SCOPING OPINION:

Proposed South Kent Energy Park

Case Reference: EN0110035

16 July 2026

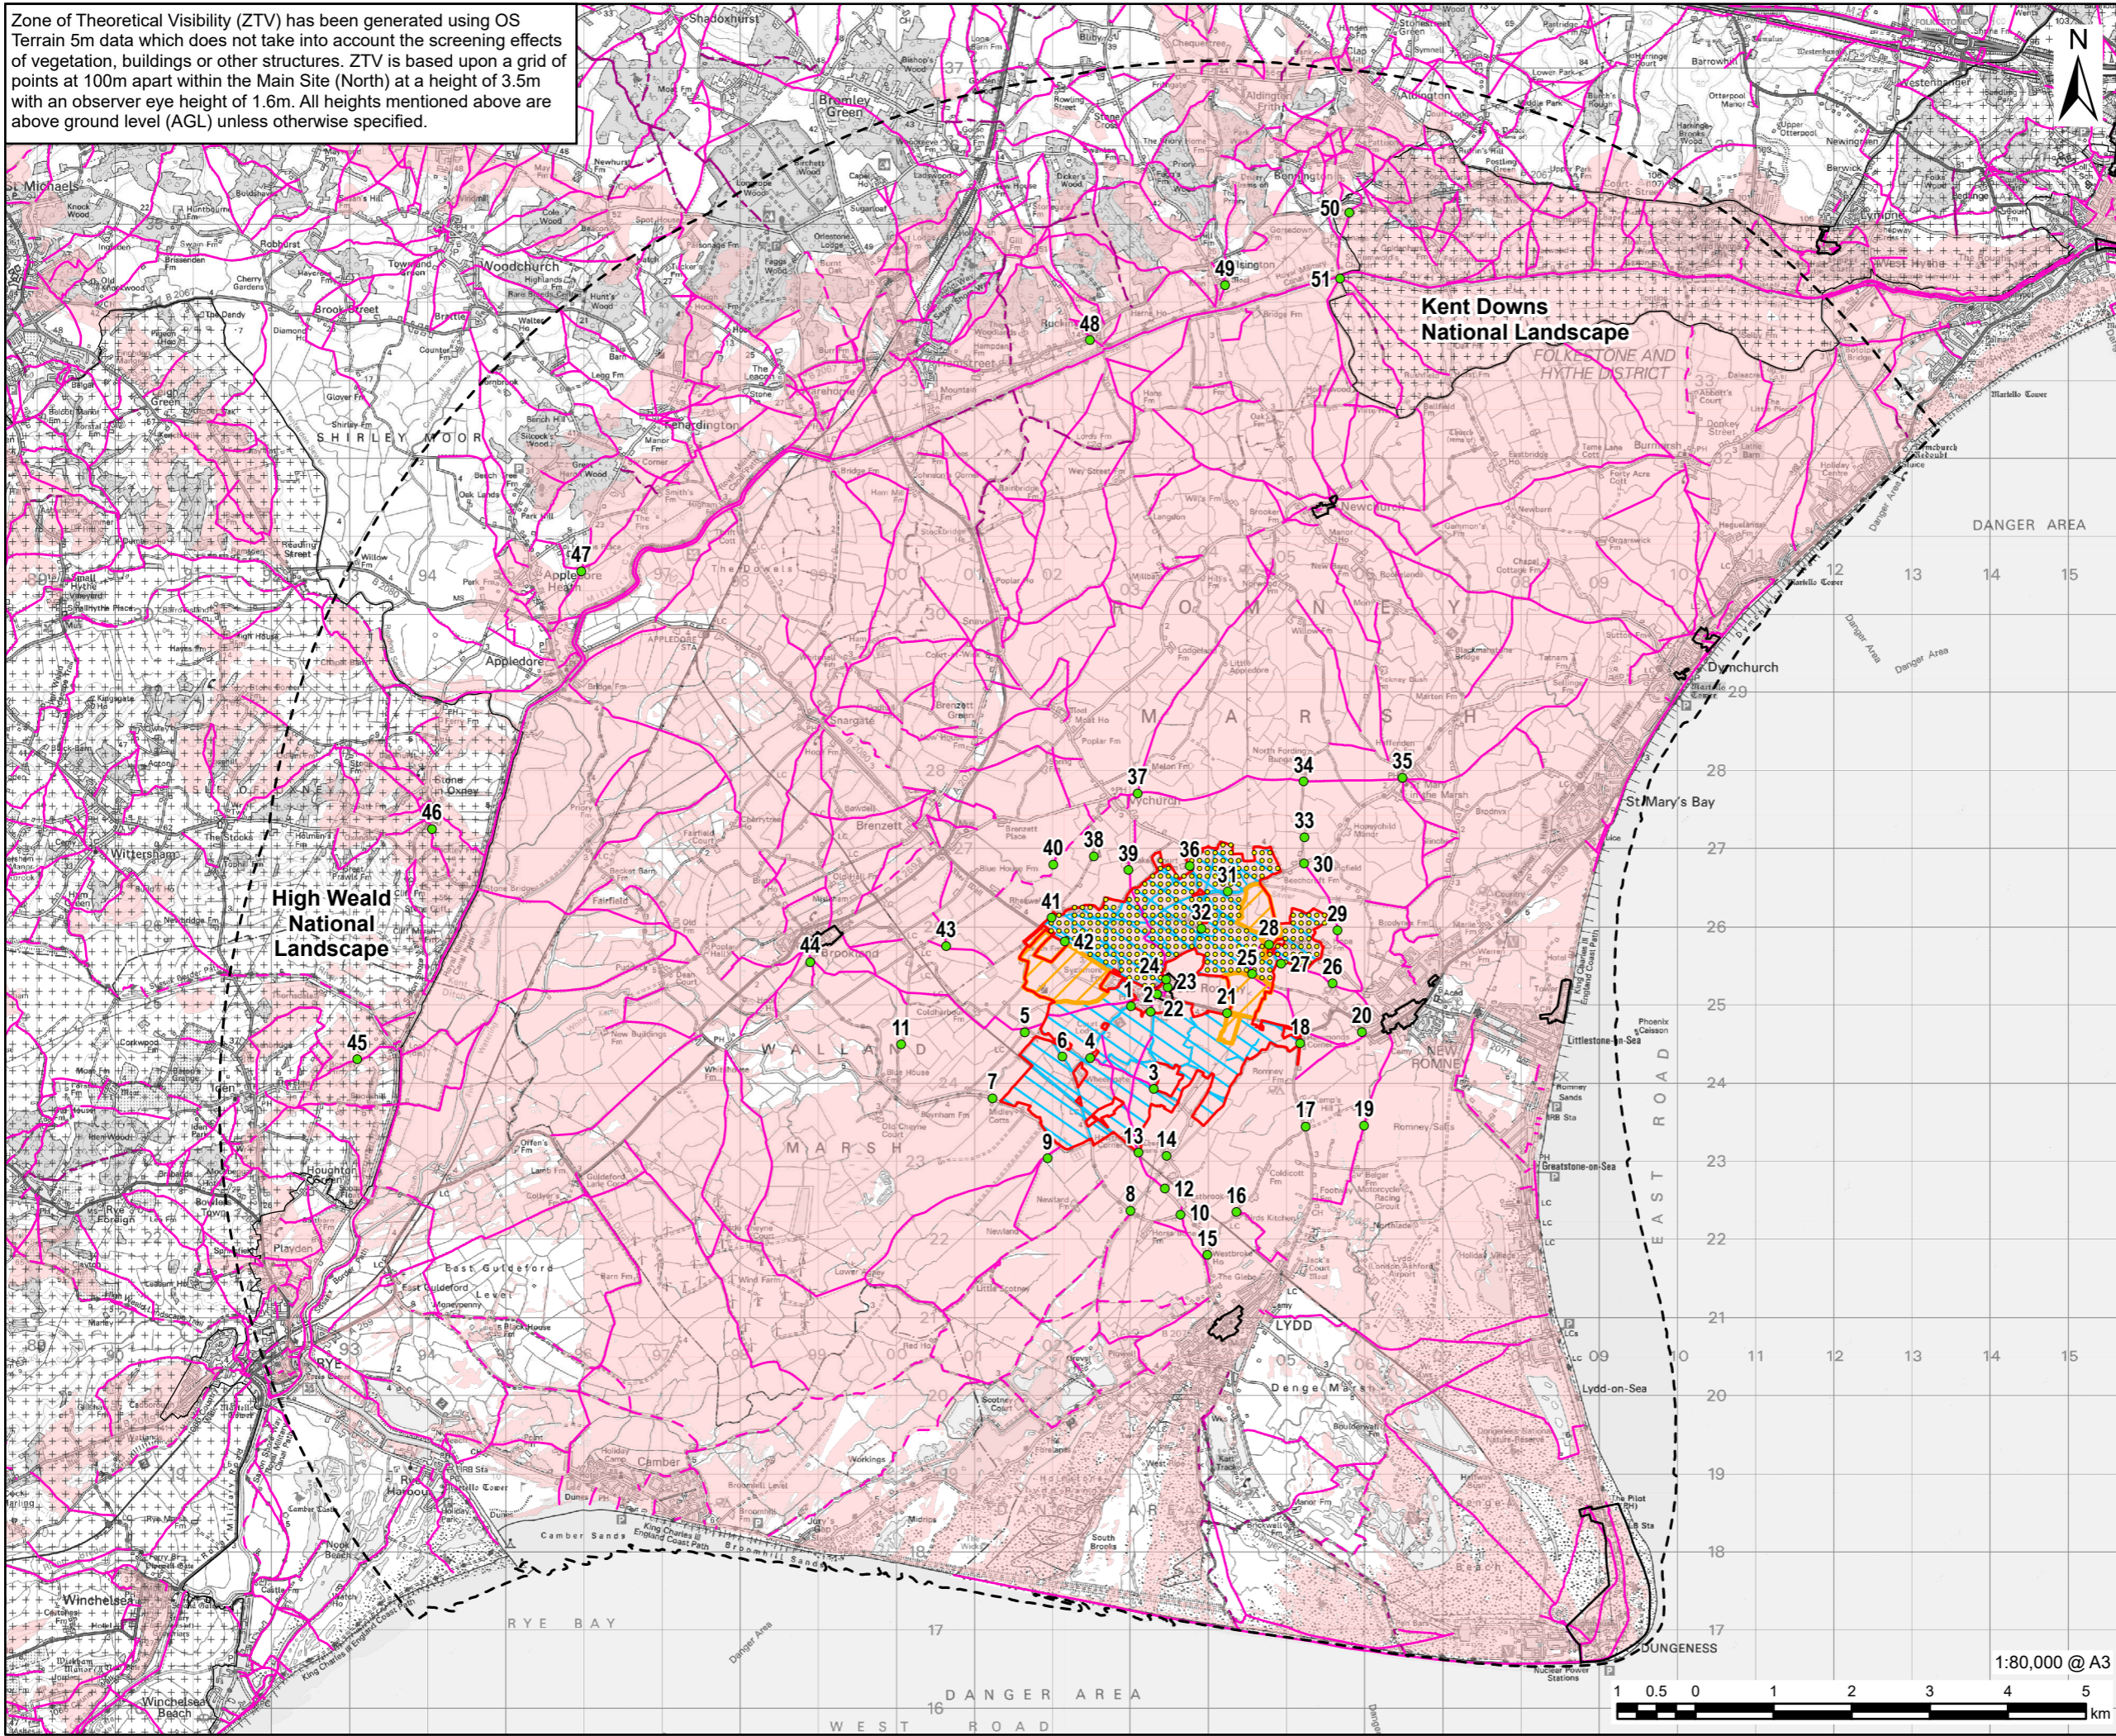
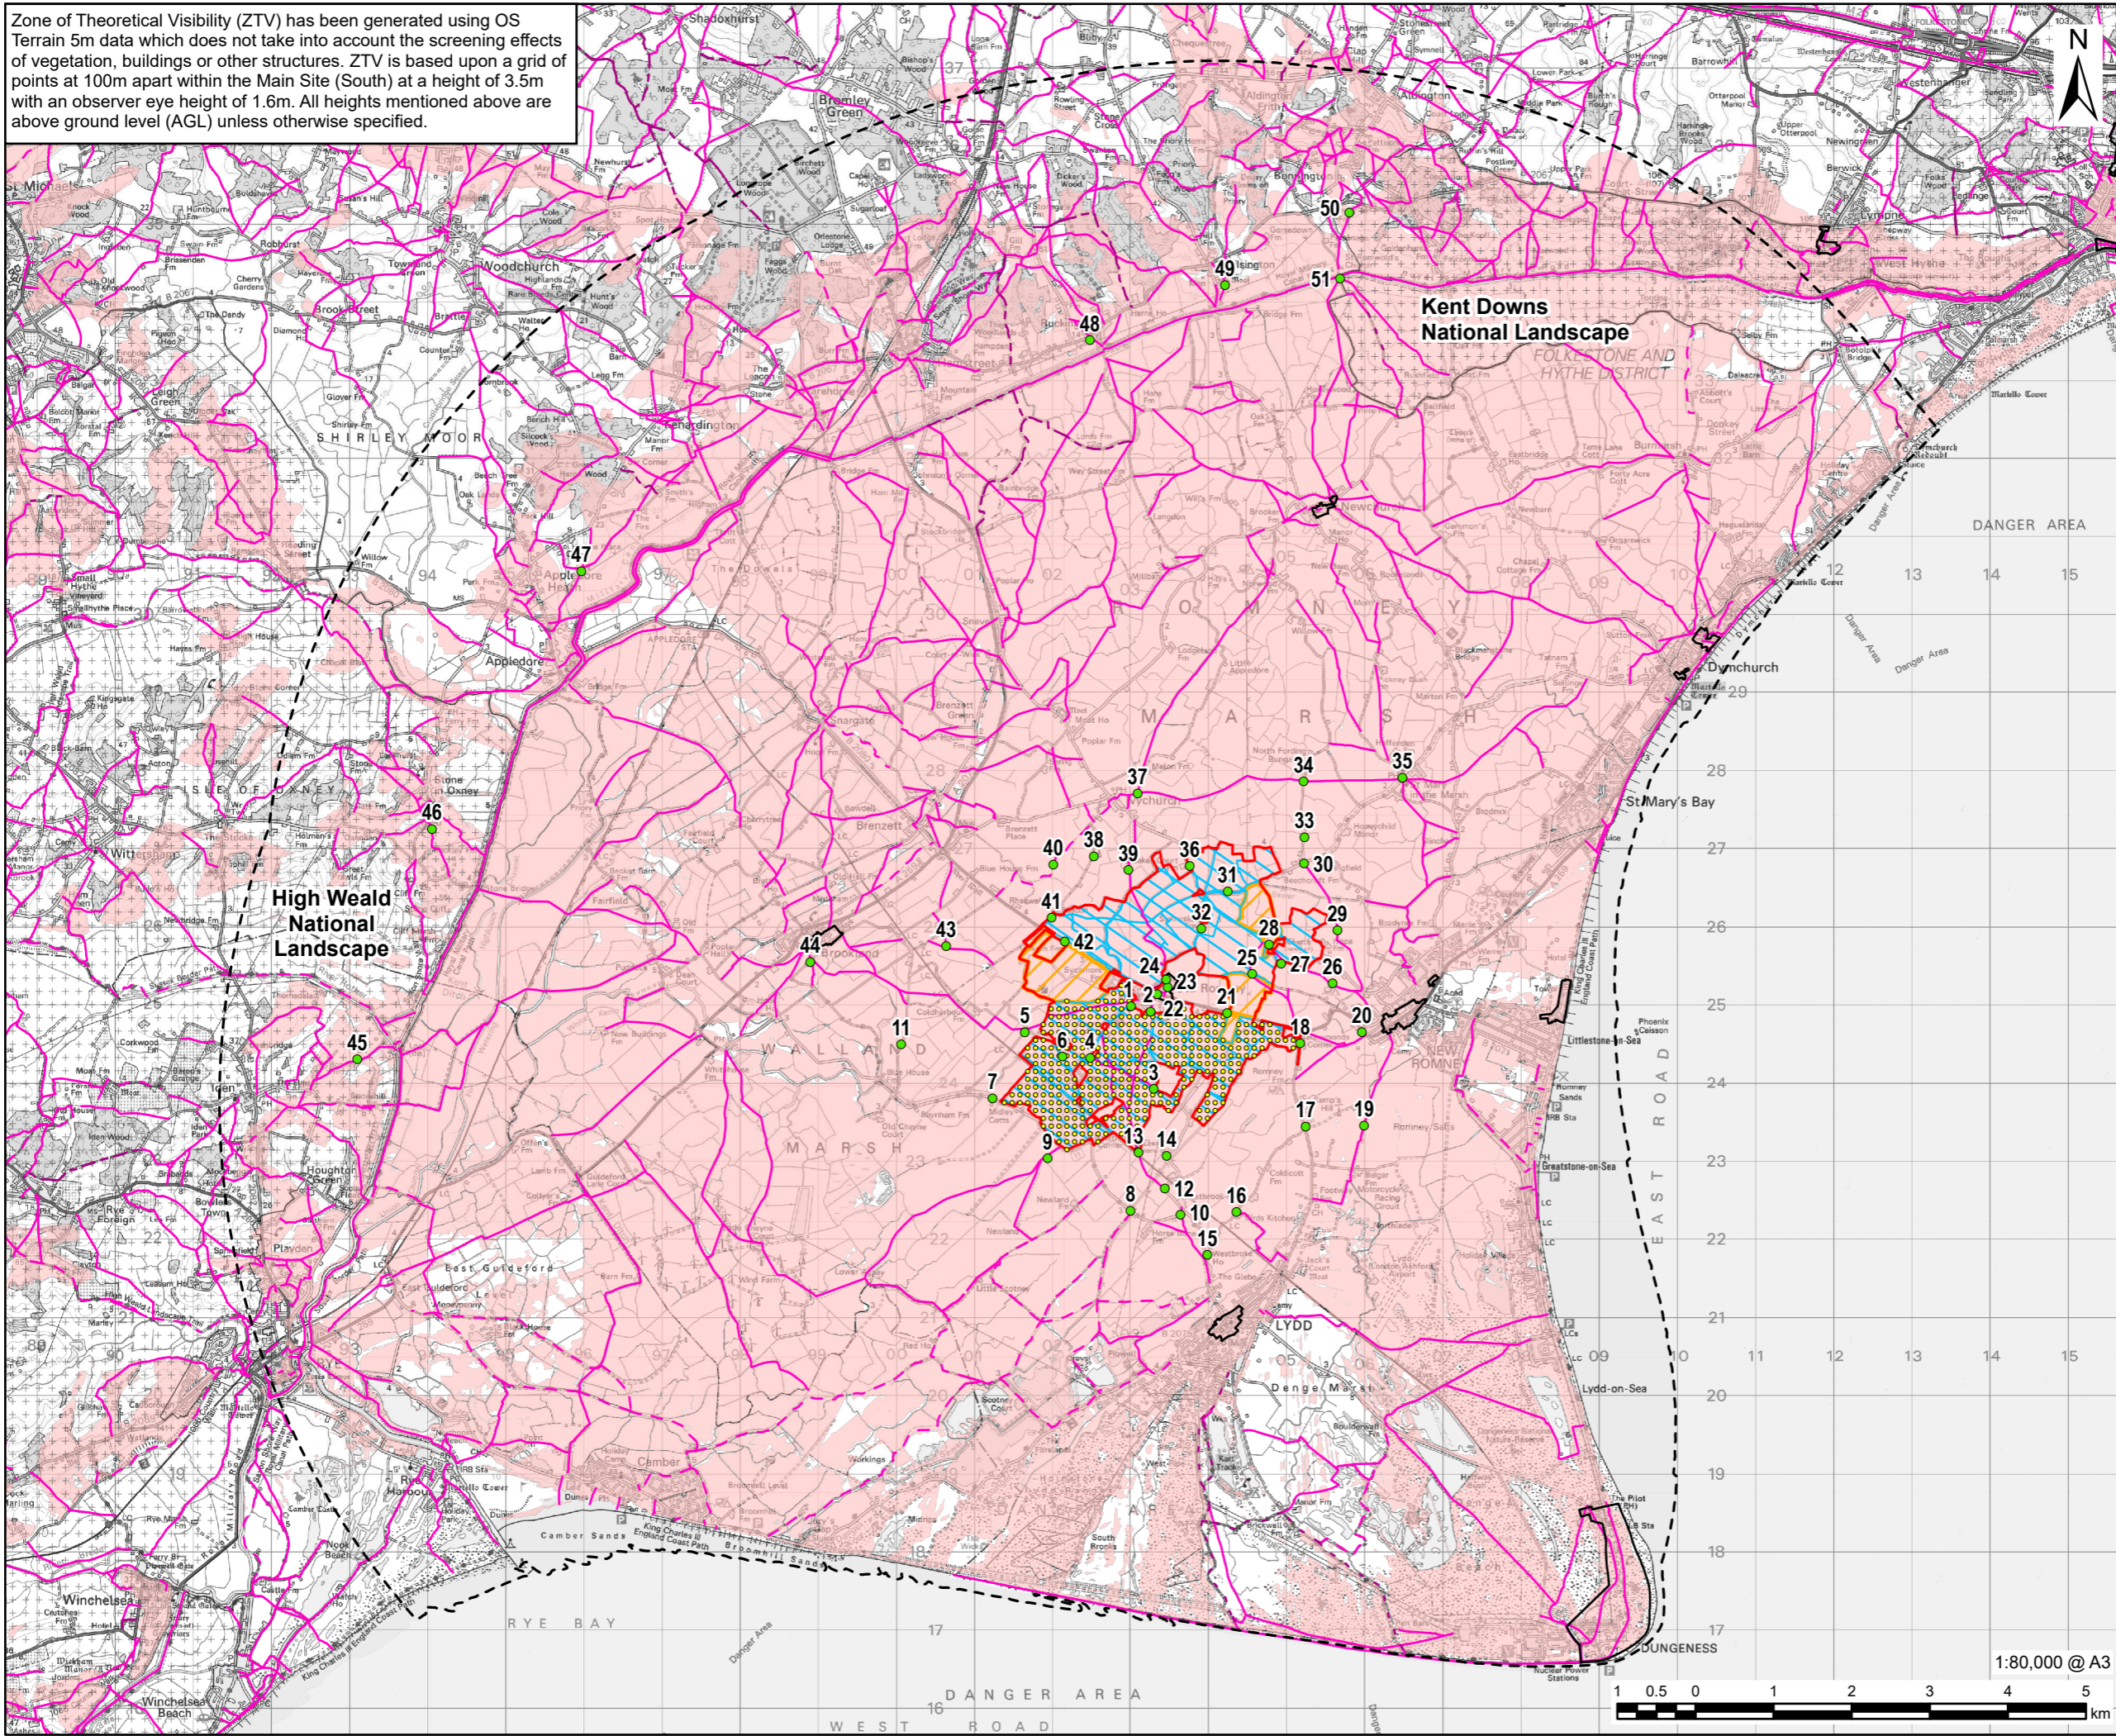
ID	Ref	Description	Inspectorate's comments
344	Section 11.2.5 Figures 11-2 and 11-3	Zone of Theoretical Visibility (ZTV)	The Scoping Report states that no ZTVs have been produced for the tallest equipment associated with the proposed development (including the on-site substations and BESS) as the locations of these facilities has not yet been confirmed. Table 3-1 of the Scoping Report states that the maximum height of the on-site substations and EKCNA National Grid substations are 13m and 25m respectively. Consequently, the ZTV may not be representative of the full extent of visibility. The ES should clearly evidence and justify the final extent of the ZTV used and ensure that any assessment of significance is based on the worst-case scenario. The cumulative visual and landscape effects with other developments in the area should also be assessed where relevant.
345	Section 11.7.5	Representative Viewpoints and visualisations	The Scoping Report states that the Landscape and Visual Impact Assessment (LVIA) will only be undertaken during winter and does not include any reference to the inclusion of visualisations in the ES. The Inspectorate considers that the LVIA should include both summer and winter visualisations to fully illustrate the effects of the proposed development.
